29 November 2012

North West Rail Link Environmental Impact Statement Stage 2 – Stations, Rail Infrastructure and Systems

**BLACKTOWN CITY COUNCIL SUBMISSION
NORTH WEST RAIL LINK
ENVIRONMENTAL IMPACT STATEMENT – STAGE 2**

Figure 14 Cudgegong Road and Tallawong Road – heavy vehicle routes

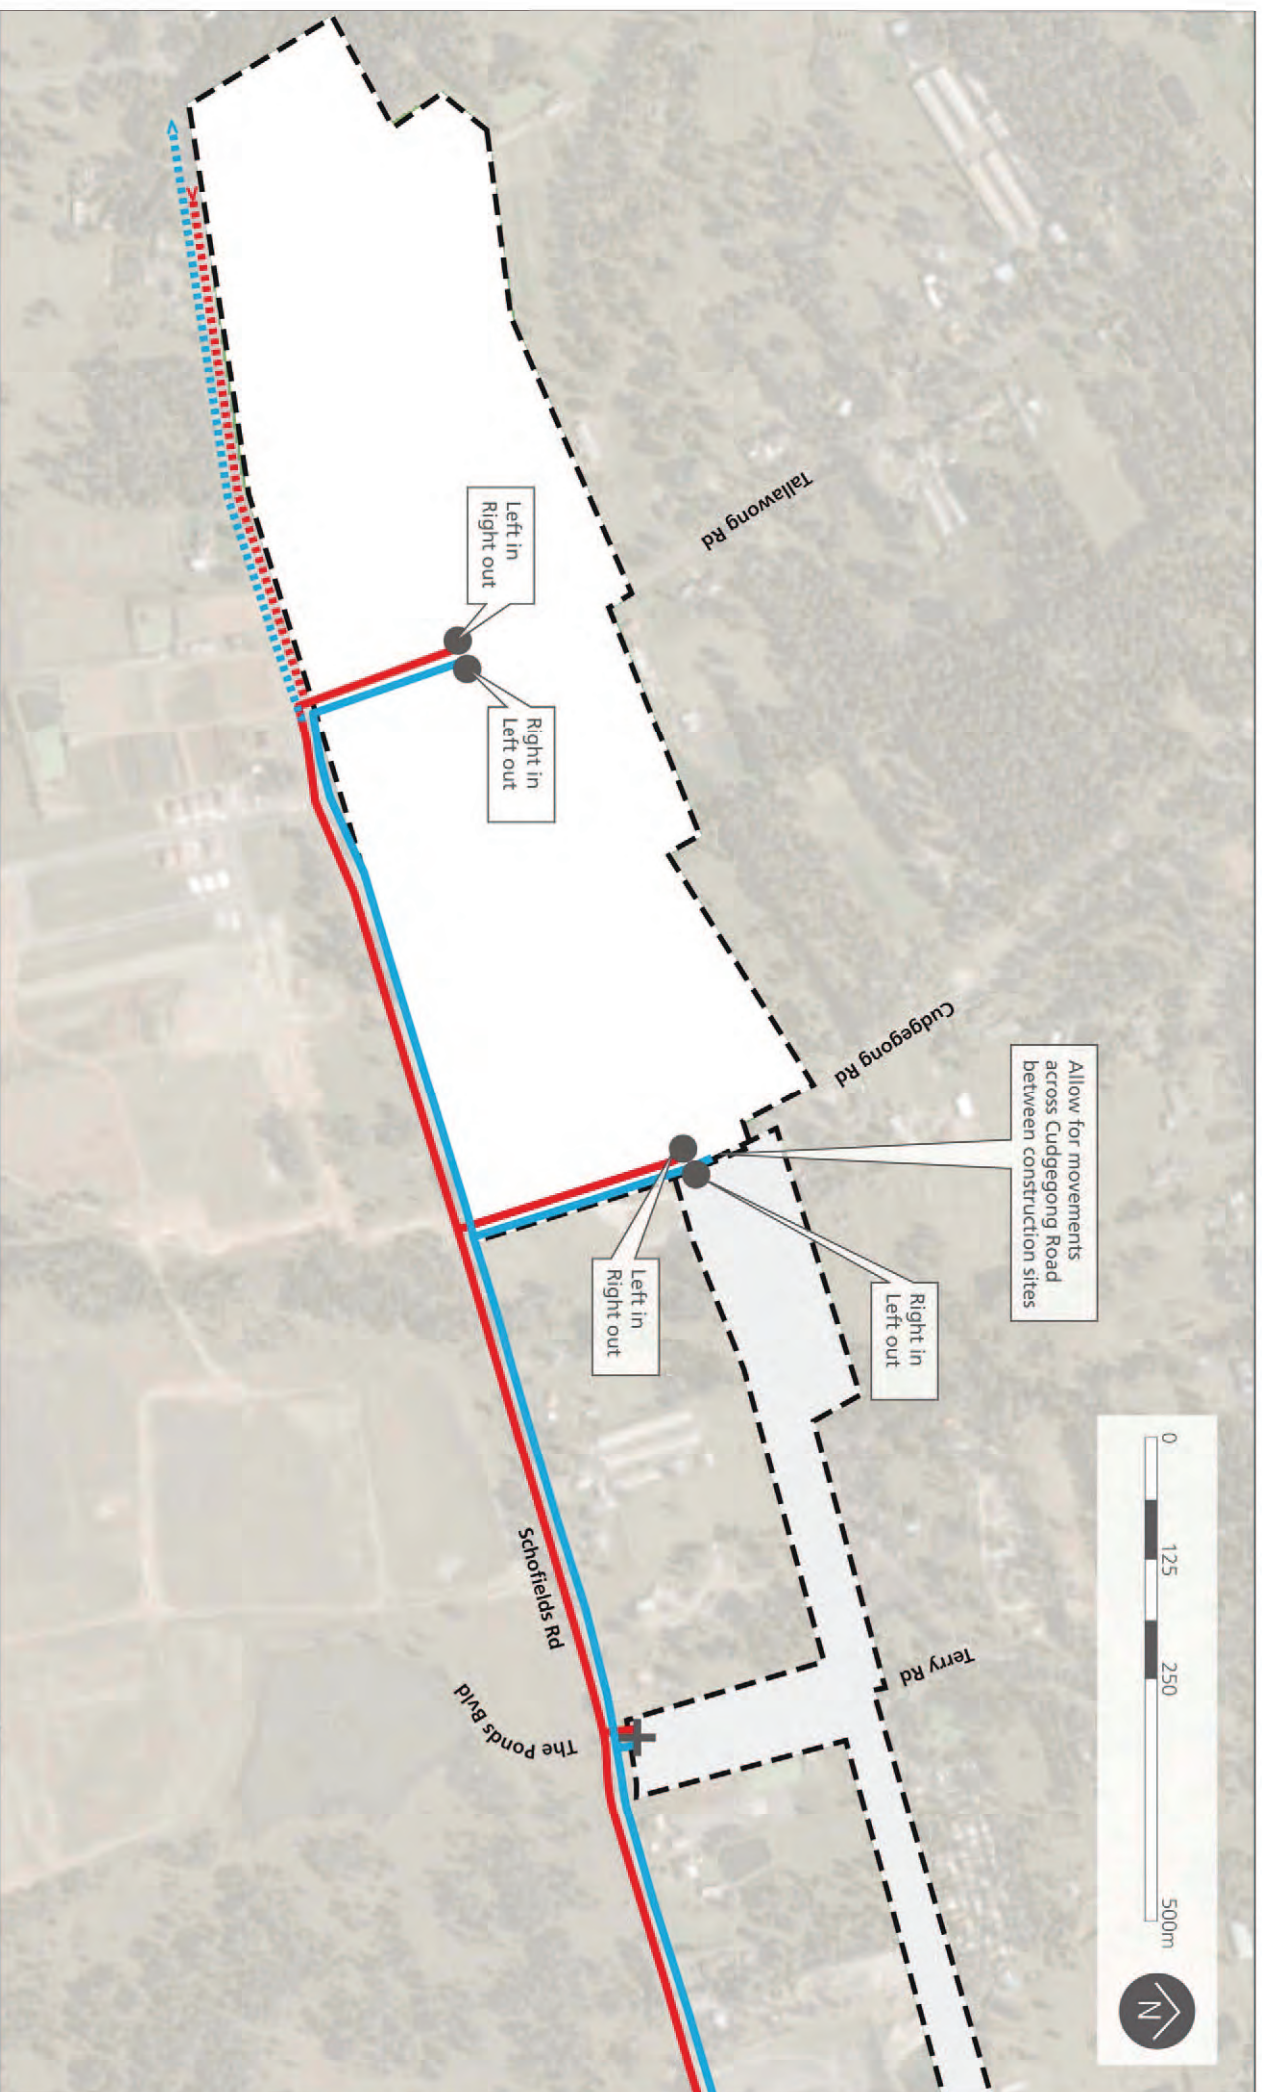
- g) The alternative access proposed for inbound and outbound heavy vehicles at the Tallawong Stabling Facility is along Schofields Road west of the facility (left in, right out). In keeping with the comment above, it is suggested that consideration be given to the removal of the proposed alternative arrangement.

Figure 6.27 Bella Vista Station - Indicative layout

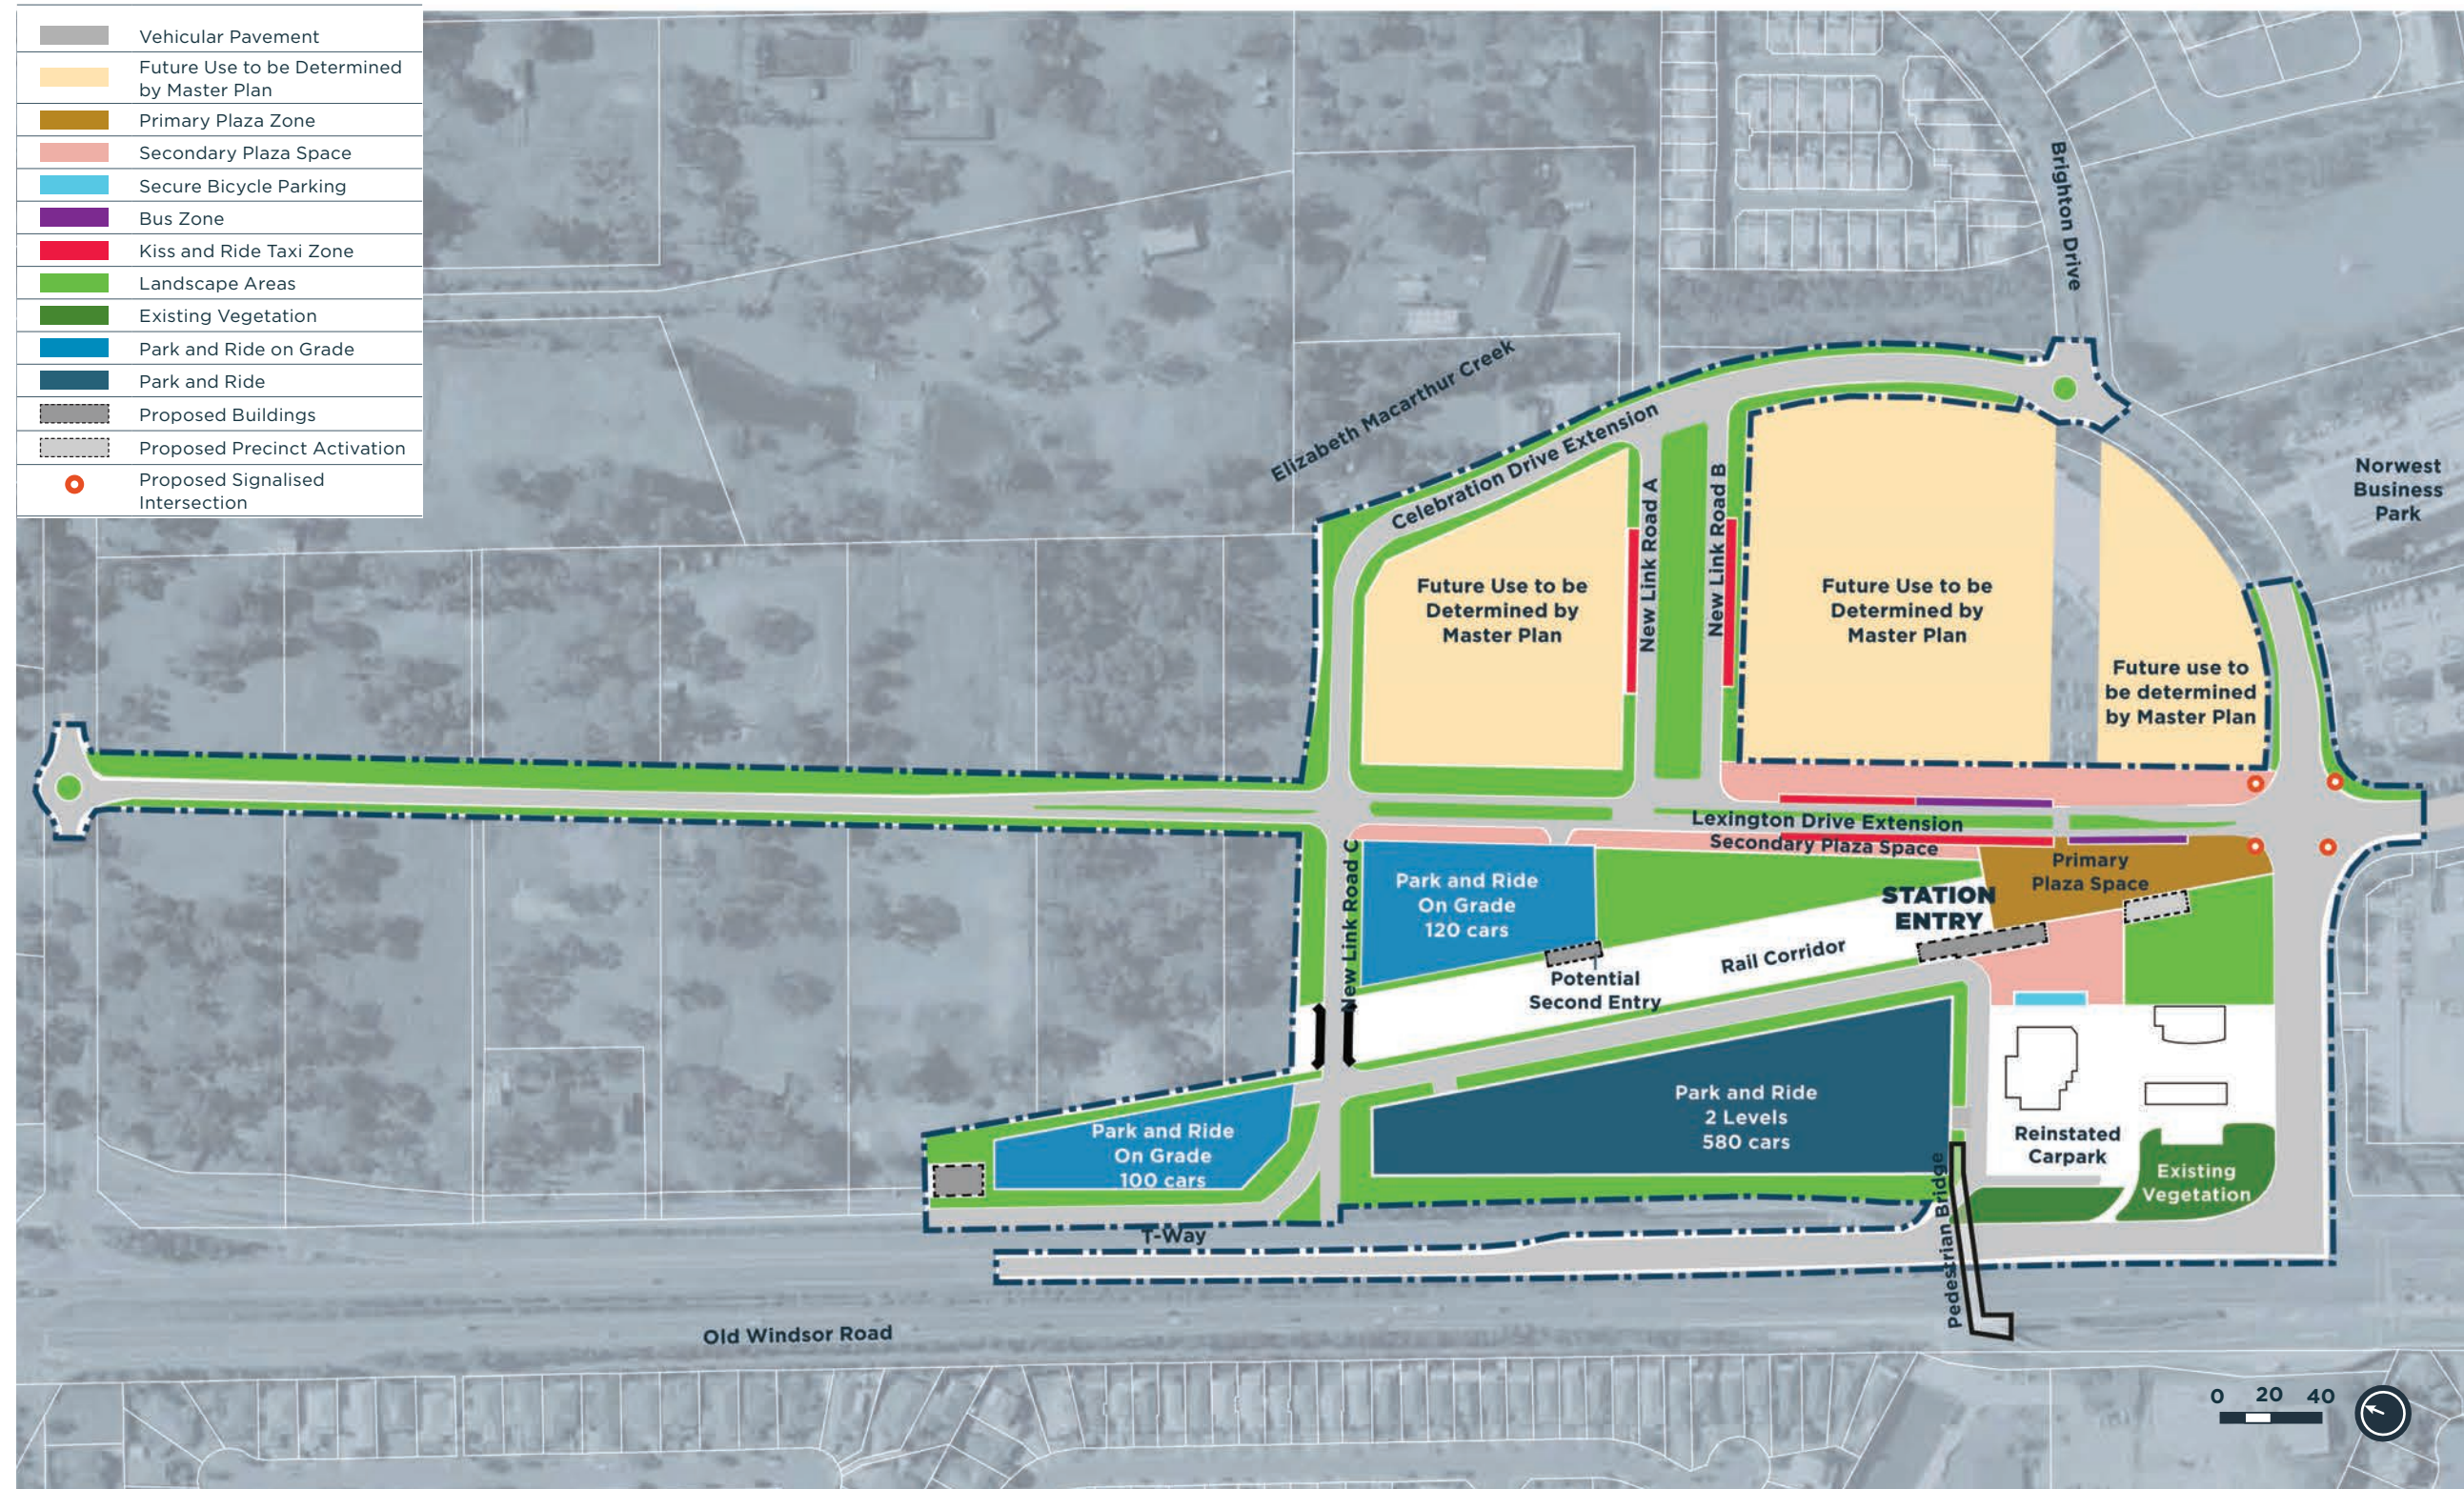
- n) Council is pleased to note that pedestrian bridges are proposed to provide pedestrian access to Bella Vista and Kellyville Stations. For both Bella Vista and Kellyville Stations, a pedestrian bridge is proposed over Old Windsor Road, as indicated on Figure 6.27 and 6.28 (Bella Vista), 6.31 and 6.32 (Kellyville). The proposed pedestrian bridge at Cudgegong Road Station will also assist in facilitating pedestrian movement from the car park to the station.
- o) These bridges should be constructed as part of the NWRL project at no cost to Council or the community as part of any Section 94 Contribution Plan for adjacent residential precincts.

Figure 6.39 Cudgegong Road Station - Indicative layout

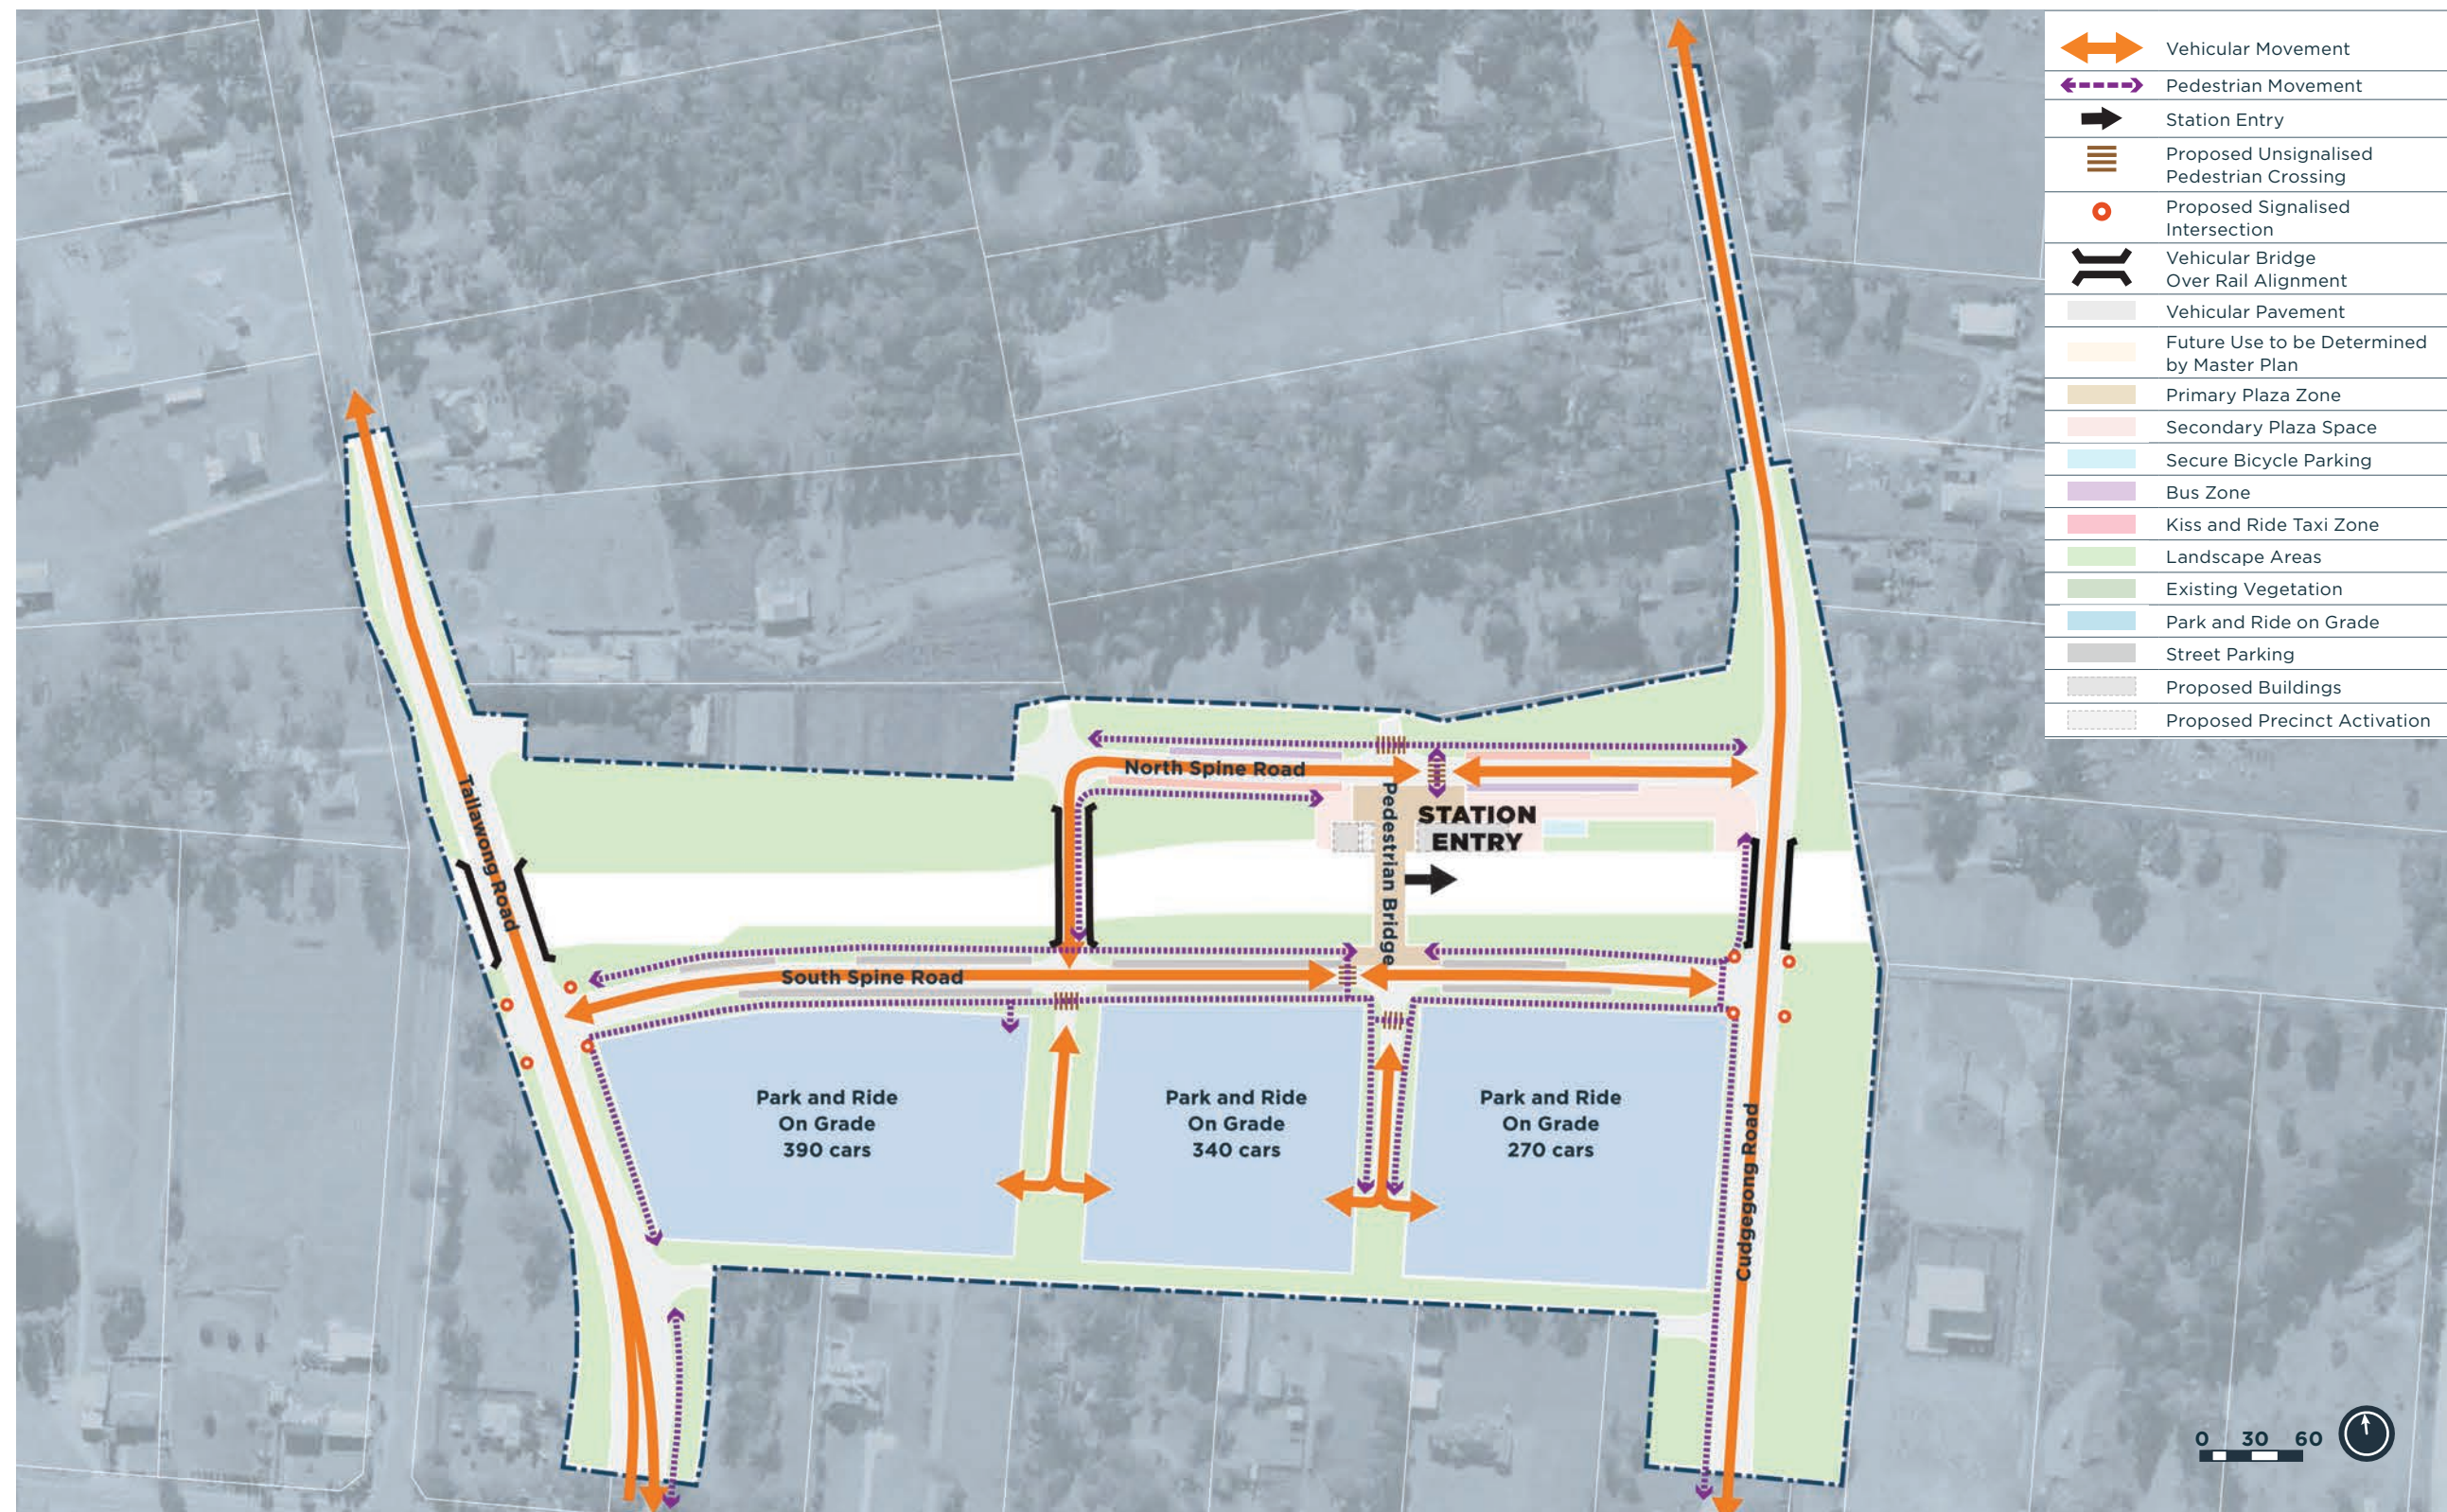
- a) The relocation of Cudgegong Road will need to incorporate access to the existing properties on the east side, particularly given the proposed Endeavour Zone Substation. The ownership of the proposed landscape area will need to be resolved (Figure 6.39).
